March 2021 BN/150/20/PL Objection Comments

OBJECTION TO PLANNING APPLICATION BN/150/PL

PLOT 3 ELEVATIONS
SCALE 1:100 @ a3

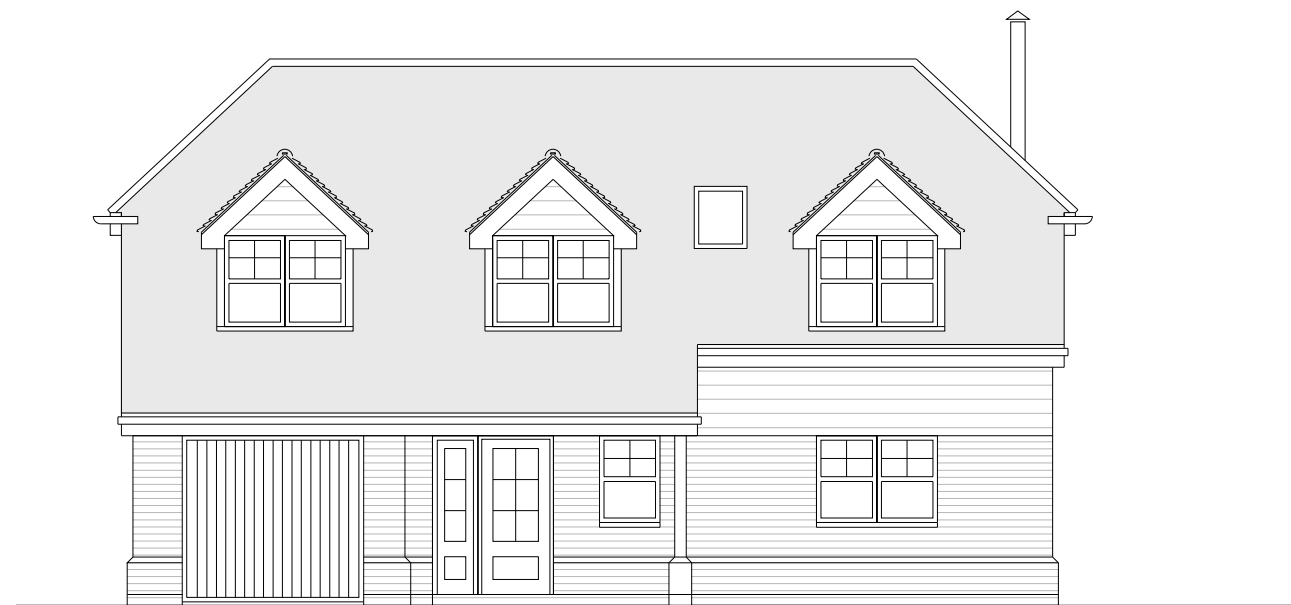
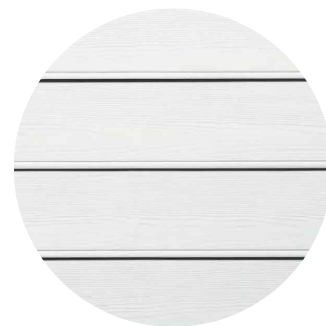
The proposal refused at 10 Downview Road (EG/108/17/OUT) placed the new dwelling 35m from the rear of the existing 2-storey dwelling, some 58m from the edge of Downview Road. BN/51/20/PL) from the rear of existing dwellings on Downview Road and 40m to 60m from the edge of Downview road. The 3 new 2-storey dwellings (8m tall) would sit behind 3 bungalows, which must adversely affect the Downview Road street scene, especially when viewed from the entrance to Chantry Mead. The roof of the proposed house No 3 will be clearly visible from Downview Road, over the roof of the bungalow at No 17 Downview Road.
